## 21 Salem St - Permit #1416

Tracie Reed <traciereed@dextrouscreative.com>  
To: Christina Stacey <cstacey@portlandmaine.gov>

I just took a look at this application you submitted for the above property. There are a couple questions/concerns:

A-1.1

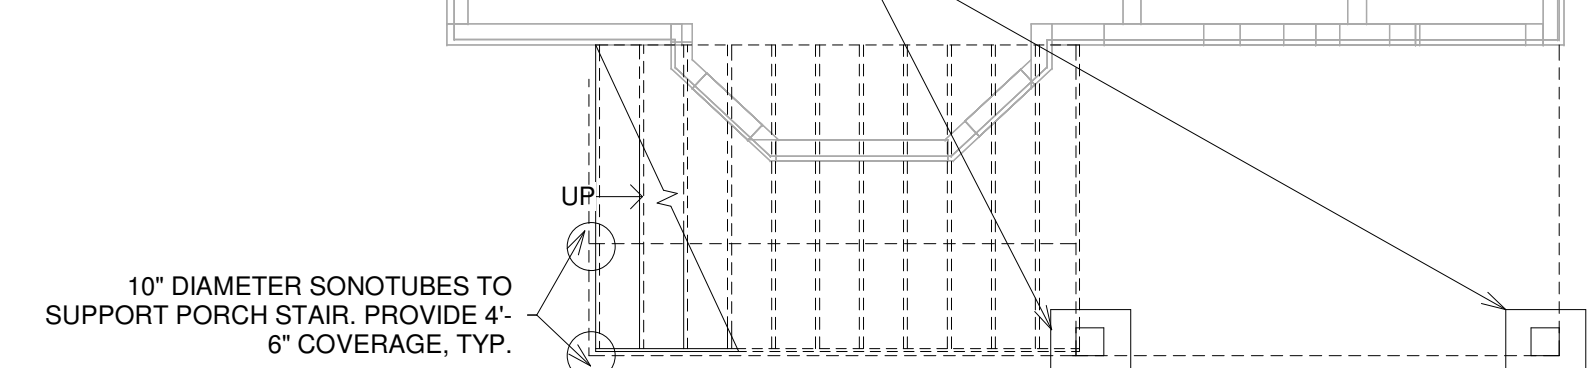
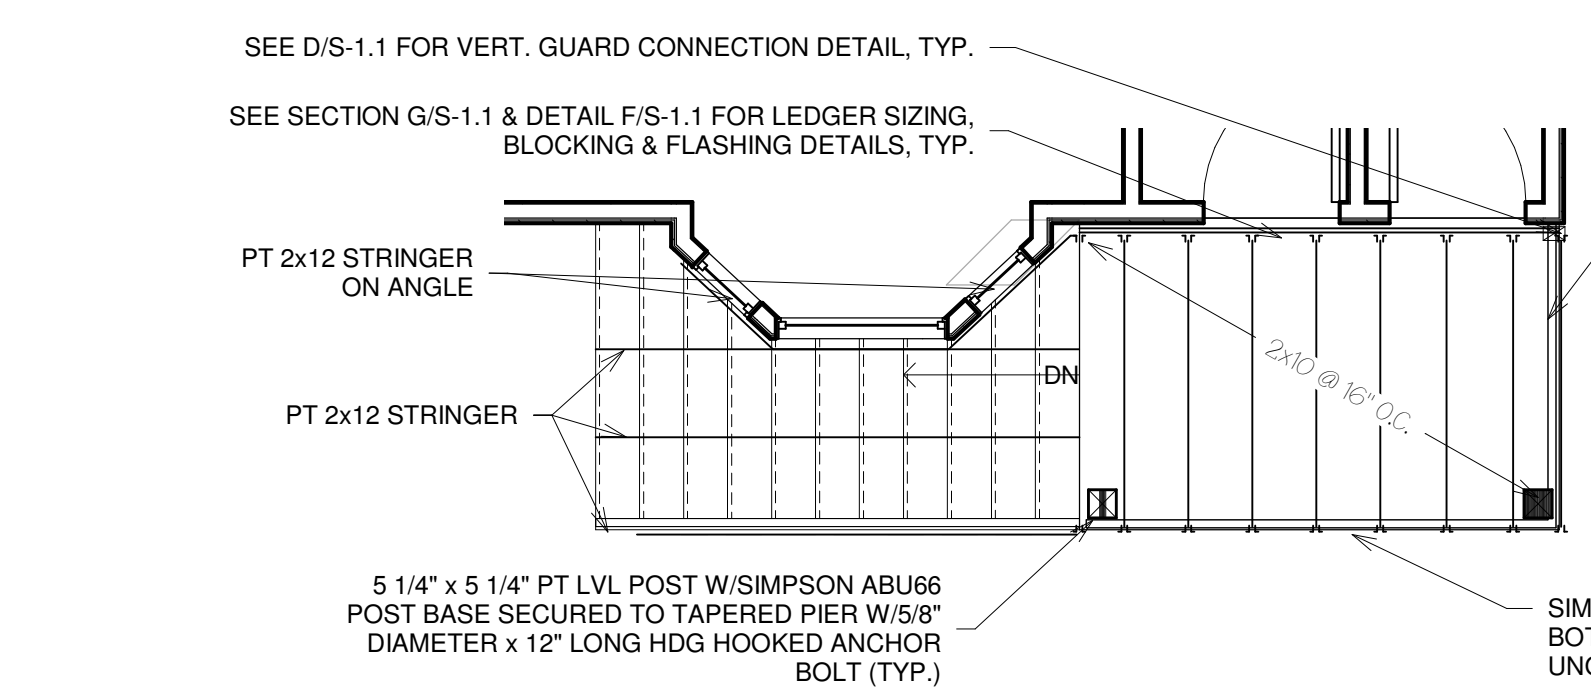
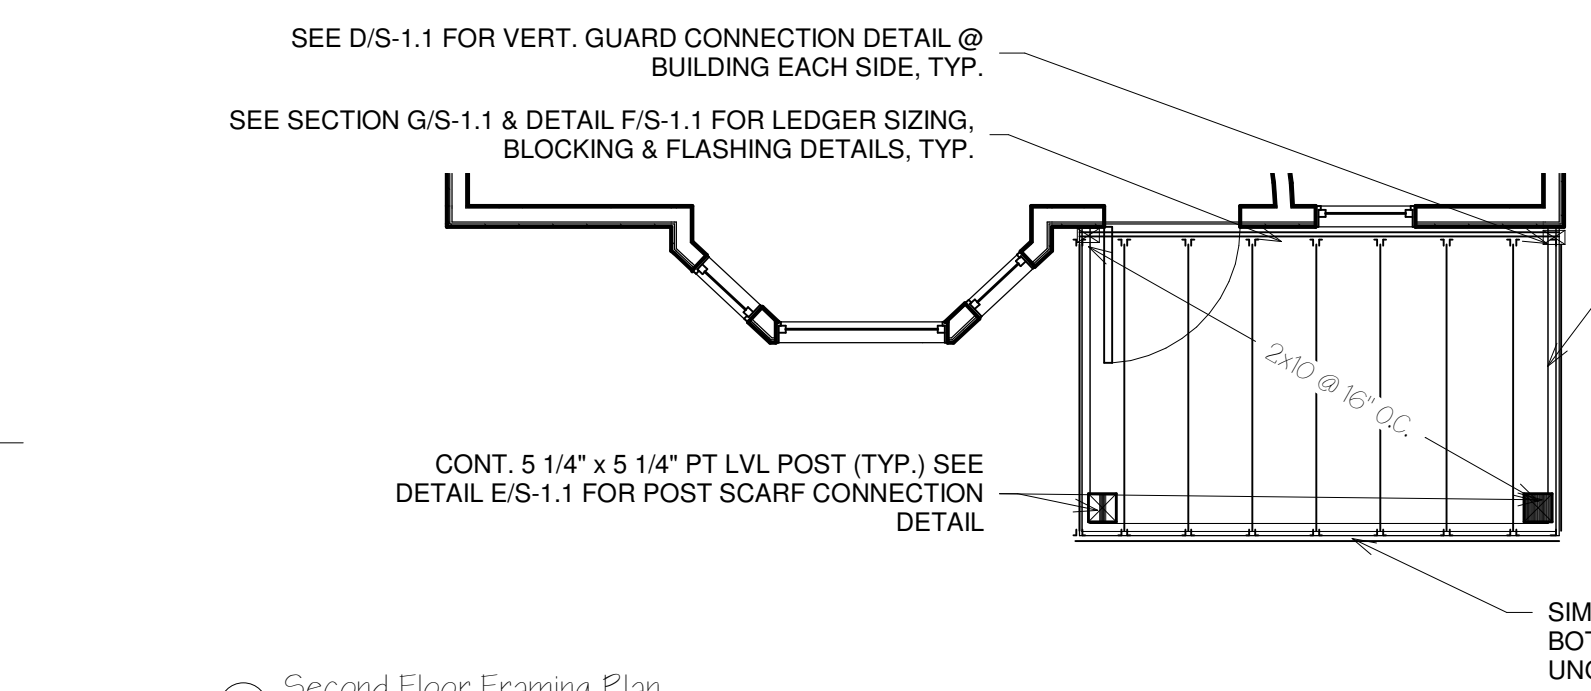
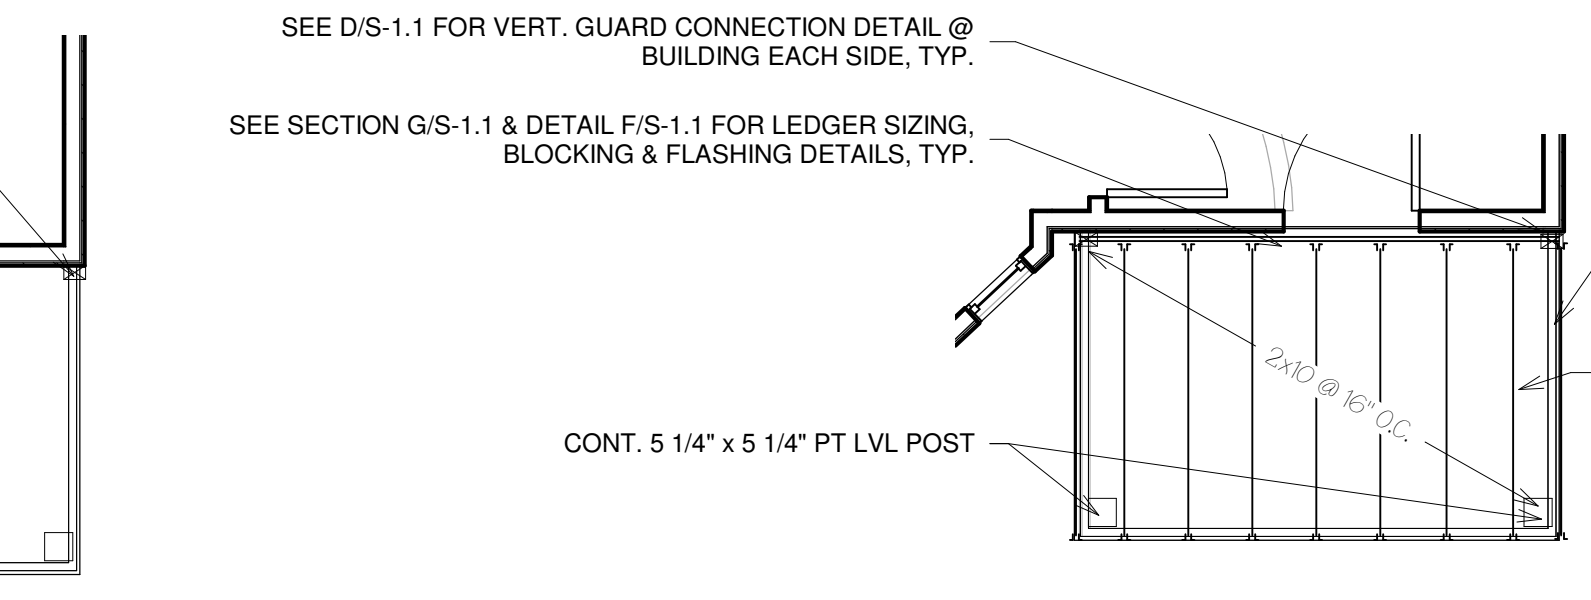
First, based on the Google Street View, it looks like the replacement front steps will be a bit longer than the existing steps. The street photo shows the current stairs ending at the middle window, and the proposed plan shows the stairs extending past the entire bay. This may be acceptable if the extension is needed to conform to building code requirements. Can you provide a brief explanation on why that expansion is needed?

Chris, Thanks for your review. At present the rise/run of the stairs do not meet current code requirements so the extension is to fulfill those requirements. In terms of the front setback you are correct that we've got a 0'-0" setback ourselves. The adjacent houses are not 0'-0" setbacks, the average may provide us a foot or so but the total depth is 6'-6" so it doesn't really seem worth it, \*ugh\* always such a tough one. Structurally and aesthetically having a tiny porch on the third porch would be very odd-looking, too.
